Subject: Planning Application BN/29/15/PL fao Richard Temple

Re Planning Application BN/29/15/PL

Figure 2 - Routing Strategy

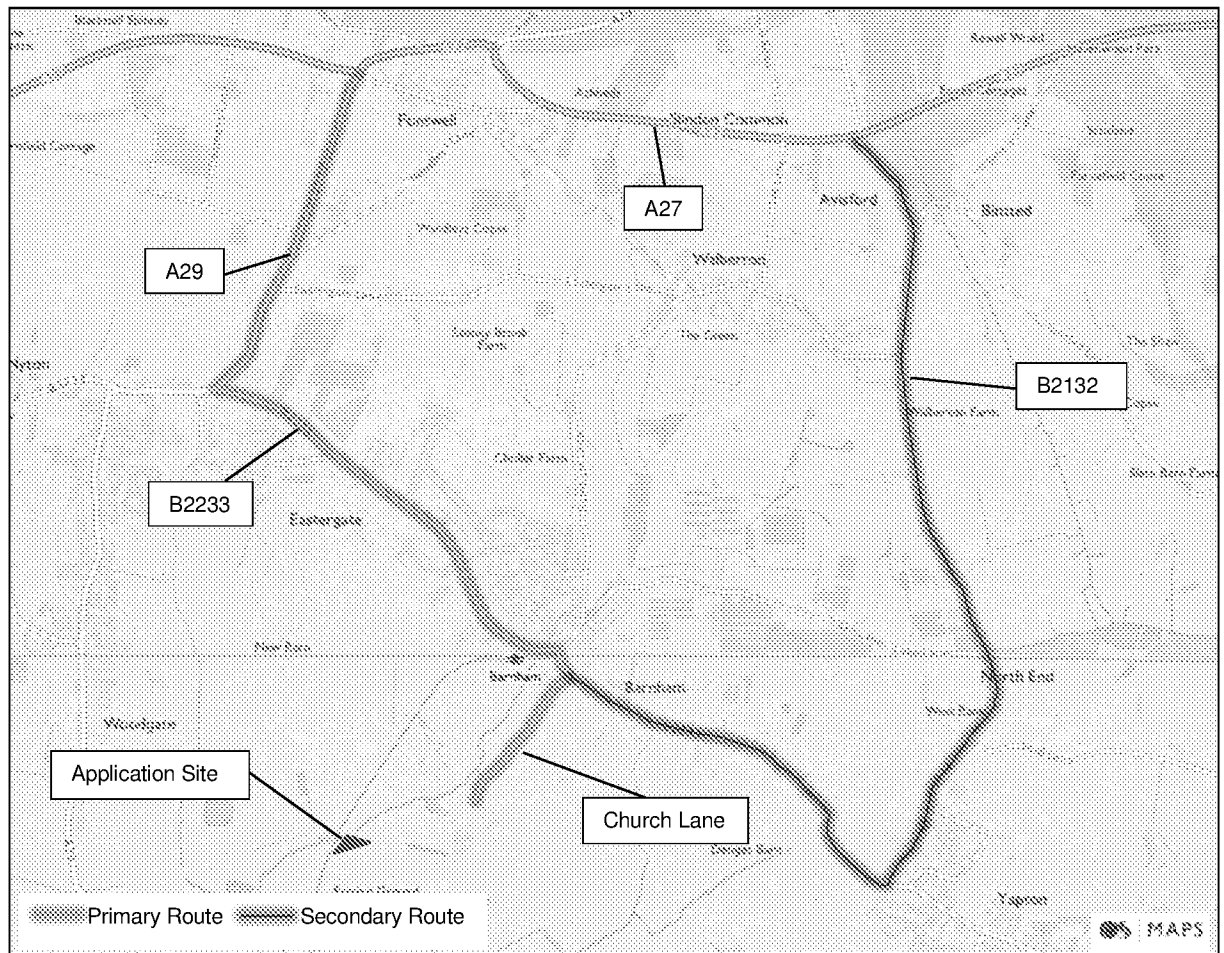
Our objection to the transport plan is the use of Church Lane, a narrow country lane, as a staging post for the transfer of the panels from large heavy goods vehicles to smaller vehicles for transporting the panels onto site.

The proposed location for the transfer is halfway down Church Lane, with nowhere for the lorries to turn, so not only will they block Church Lane when they transfer the panels, they will still have to travel the length of Church Lane to find somewhere to turn causing major disruption to the many residents of the Lane.
